Ann Machado - Re: Banners along Thompson's Point Road

From: Chris Thompson <parallaxpartners@gmail.com>
To: Ann Machado <AMACHADO@portlandmaine.gov>
Date: 6/1/2015 5:23 PM
Subject: Re: Banners along Thompson's Point Road
CC: Barbara Barhydt <BAB@portlandmaine.gov>, Sue Santere <sue@thompsonspoint...>
Attachments: THOMPSON'S POINT ROAD AERIAL.pdf; TP ROAD LIGHTING PLAN.pdf

SITE LIGHTING PLAN - PART 1
 T = 30'

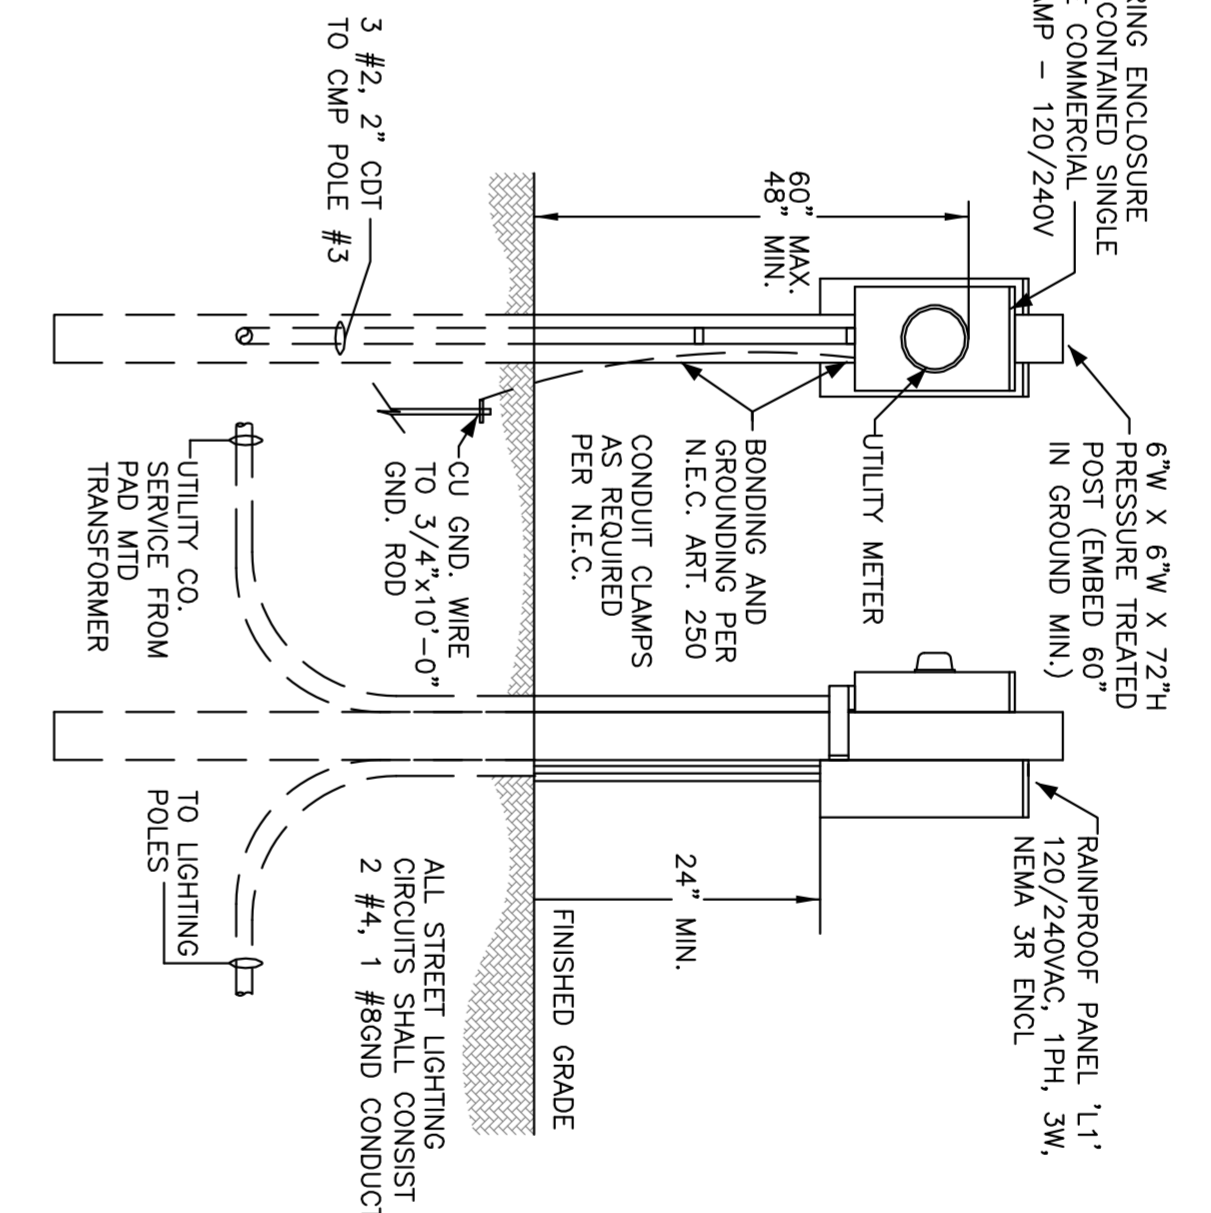
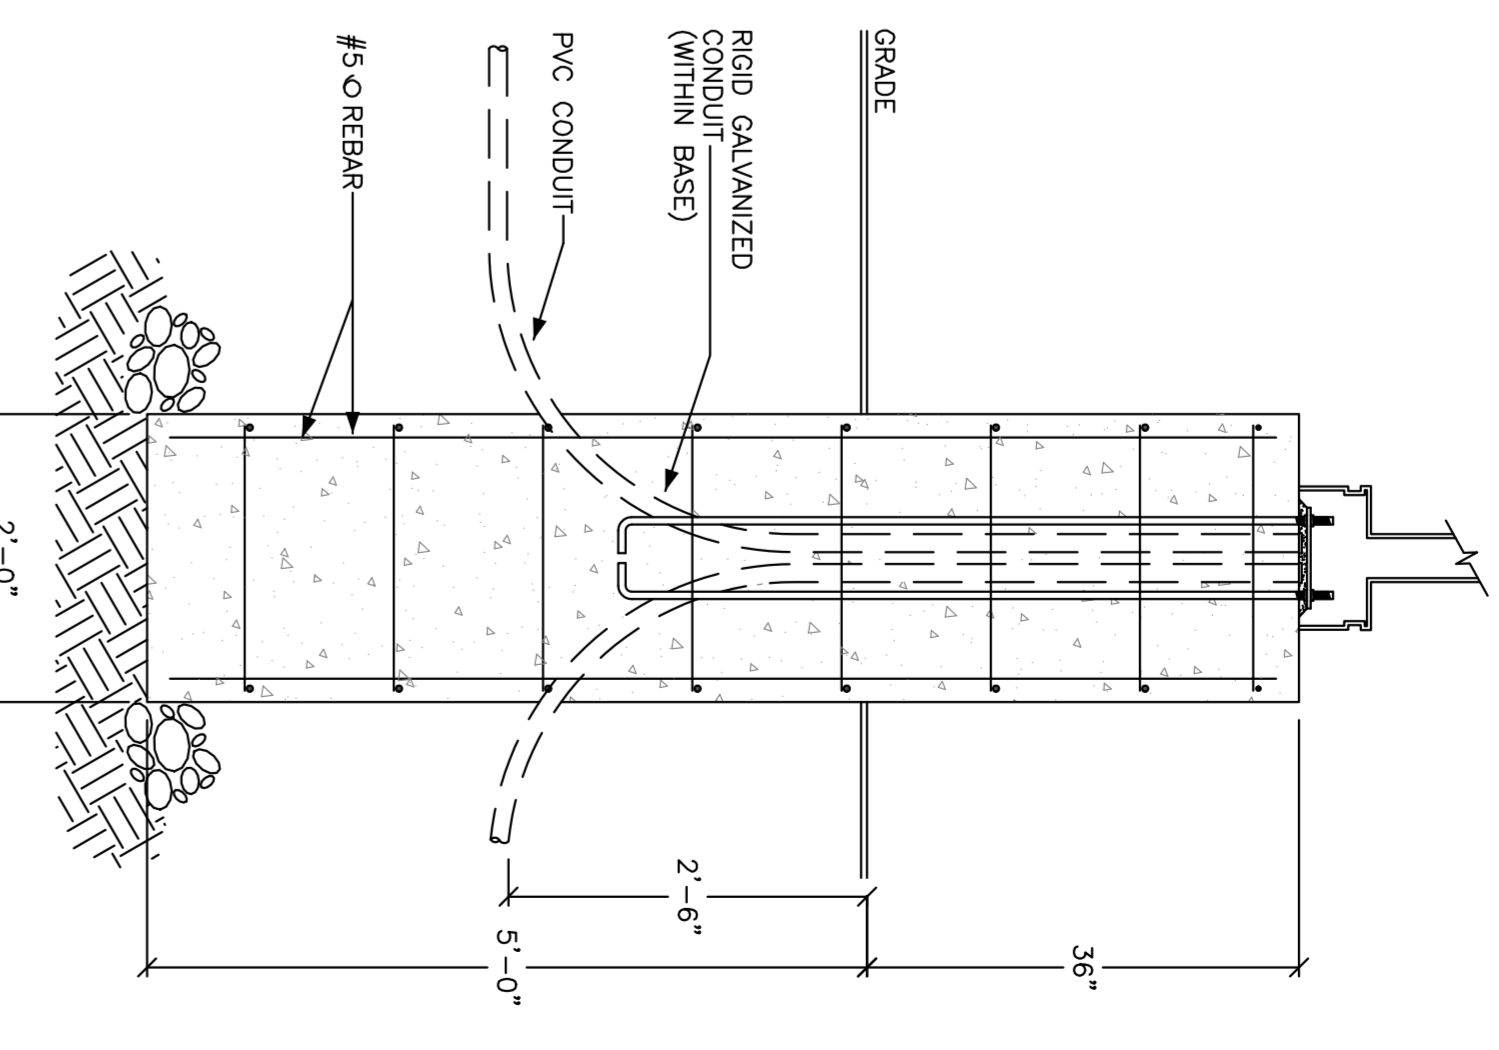
With sign/banner permit applications we usually get a site plan that shows where the banners are located. From the picture provided, I can only see the first light pole. A goggle earth picture showing the light poles would suffice.

Finally we need details on how the banners will be attached to the light poles.

Please see attached aerial view and site plan view noting the fixtures to which we are proposing to add banners.

The banners are stitched at top and bottom to create loops that slide onto the existing banner posts on the light poles.
